TRI-STATE GENERATION & TRANSMISSION, INC.

FOX RUN SUBSTATION FINAL DRAINAGE REPORT

PCD FILE # PPR-22-044

March 21, 2023

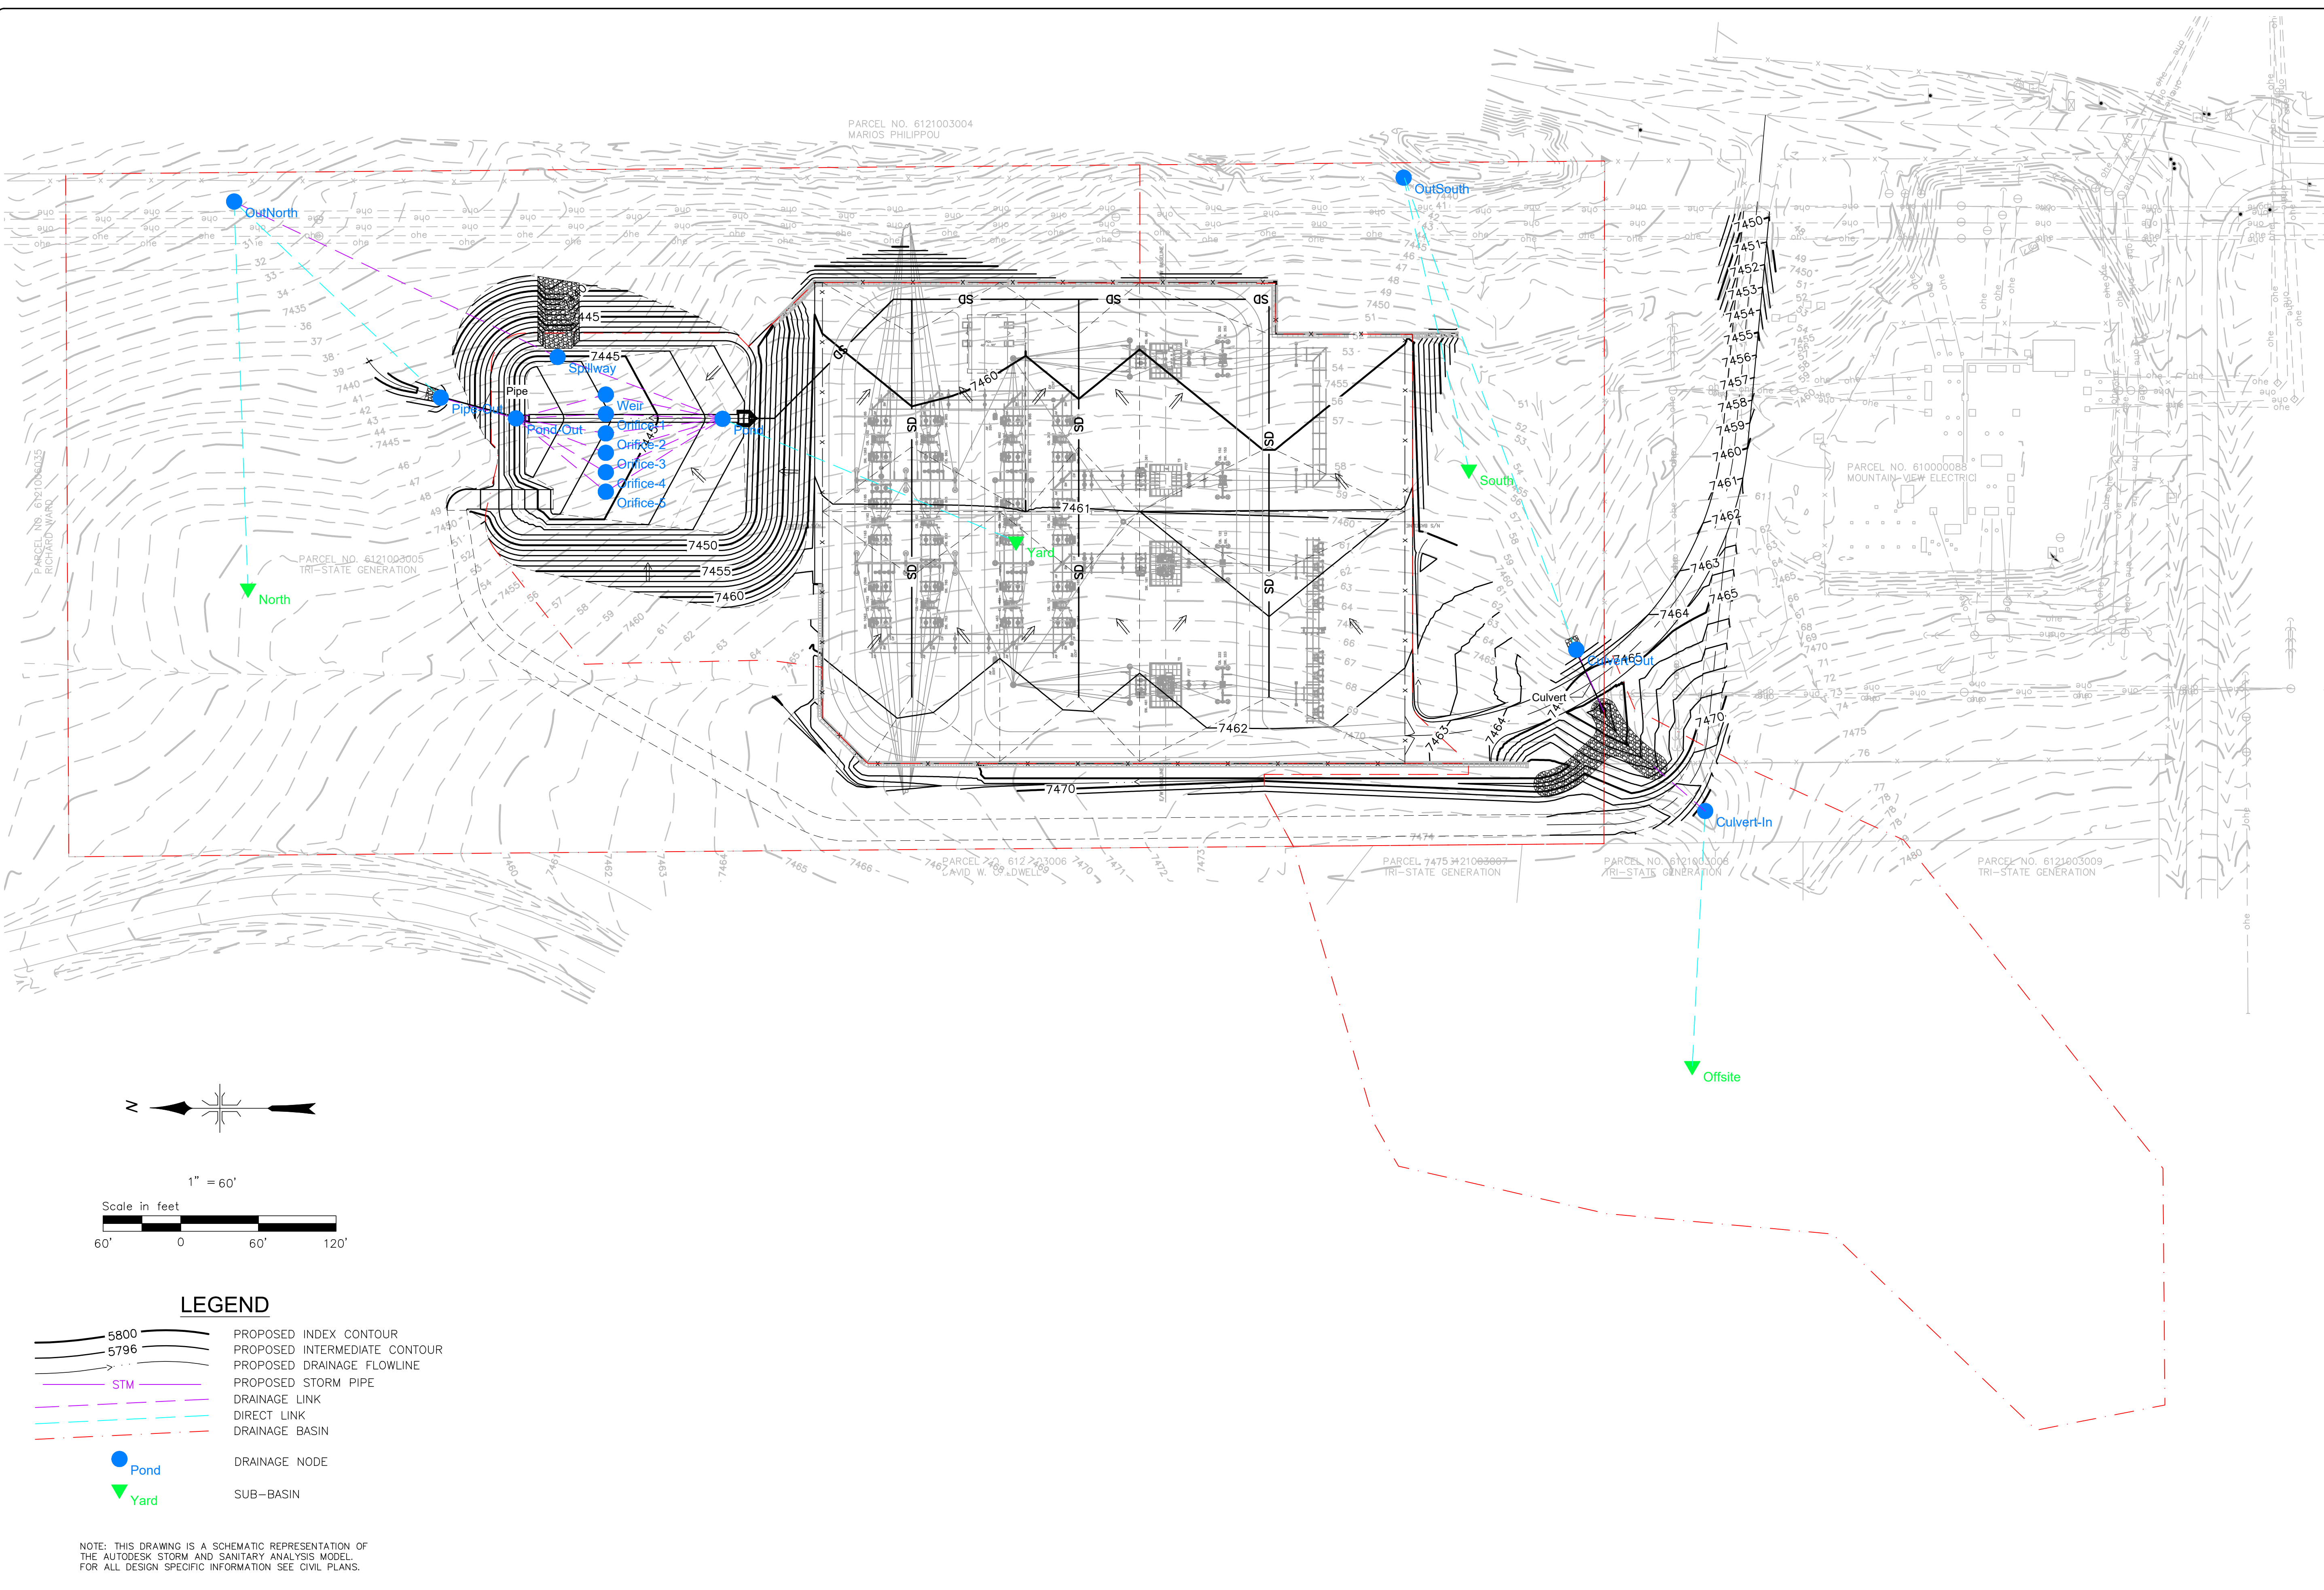
100-year event discharge is 12.7cfs (see UD-Detention Spreadsheet)

does not match UD-Detention calculations

Please address the comment on Drainage map concerning the pond outlet flow
